Aldingbourne Parish Council
Aldingbourne Community Sports Centre
Olivers Meadow
Westergate
Chichester
PO20 3YA

Application No: AL/34/22/PL
Site Address: Land At Wings Nursery Lidsey Road Woodgate PO20 3SU
Description of works: Variation of conditions imposed under AL/20/21/PL relating to conditions 2-plans condition (three bungalows changed to two storey houses, other elevation detail changes and highway drawings amended to reflect layout changes) and 5-hours of demolition/construction (to make it so that the additional bat working restrictions do not apply outside of bat hibernation times) .

Thank you for your internet representation made on 14th April 2022 which has been recorded as an objection with the comments as follows:

Drawing title									
Proposed Plans & Elevations Units 3-4									
Drawn	Date	Checked	Date	Scale at A1					
JK	JAN 21	HUG	JAN 21	1:100					
Job No.	Pro.	Org.	Zone	Level	Type	Role	No.	Rev.	
19-121	LID	MHA	00	XX	DR	A	0111	03	
Purpose of Issue									
PRELIMINARY

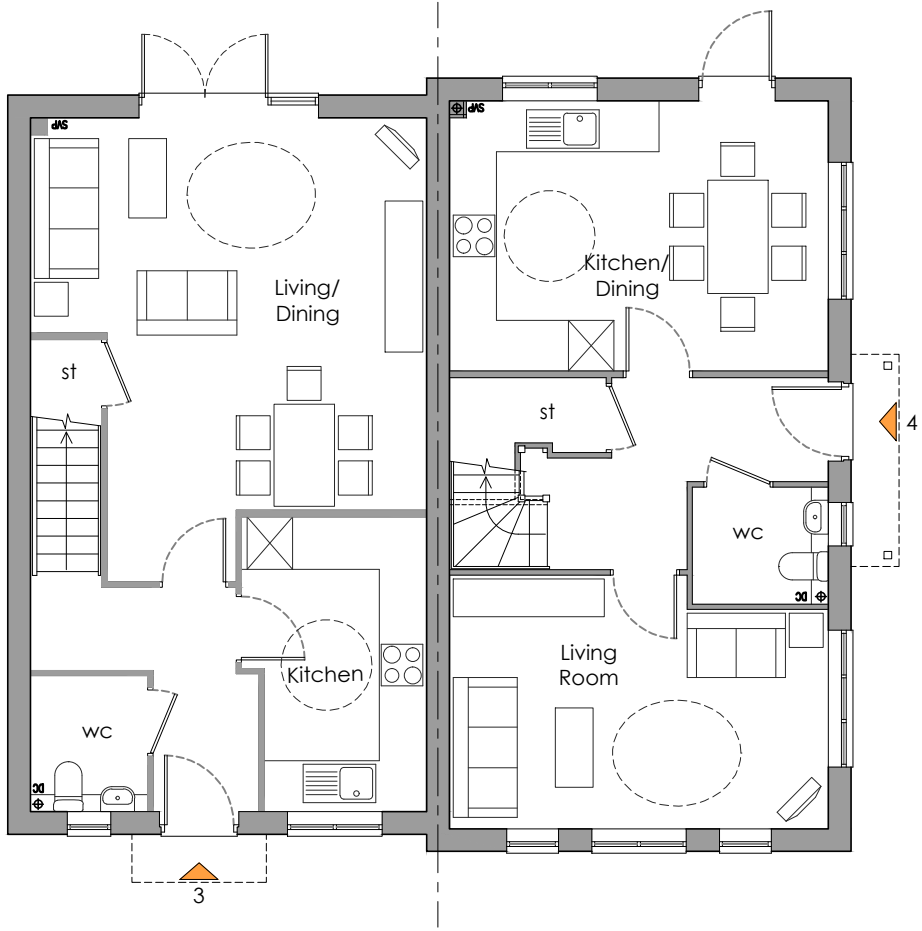
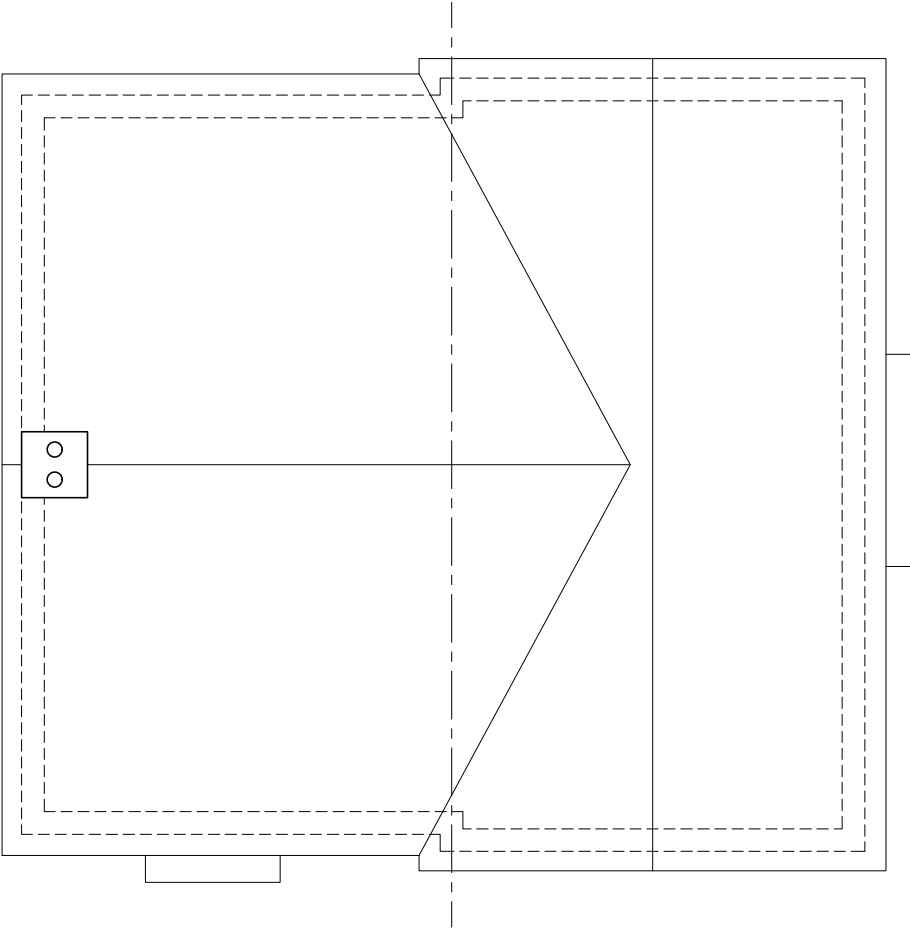
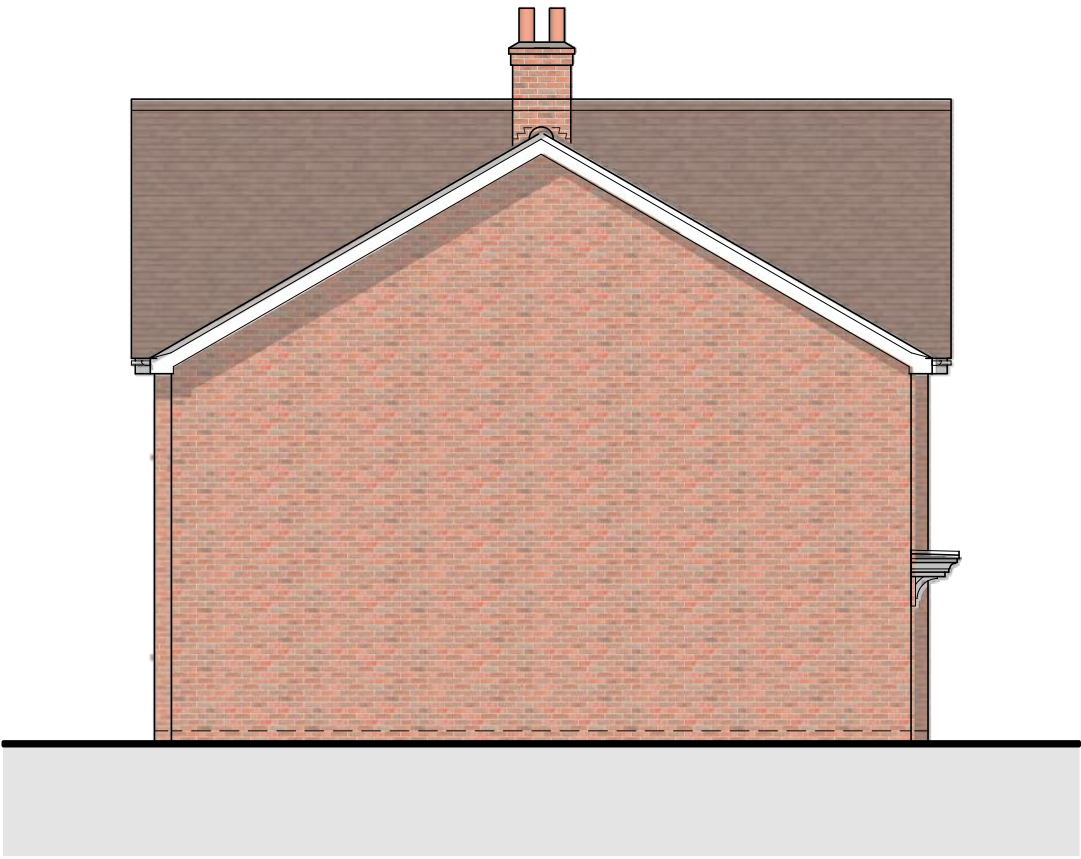
The Parish Council is disappointed in the late changes to the development and the request to change the bungalows to two storey houses. This does not allow for anybody with a disability and precludes them from the development. For the purposes of inclusivity we object to the requested changes.
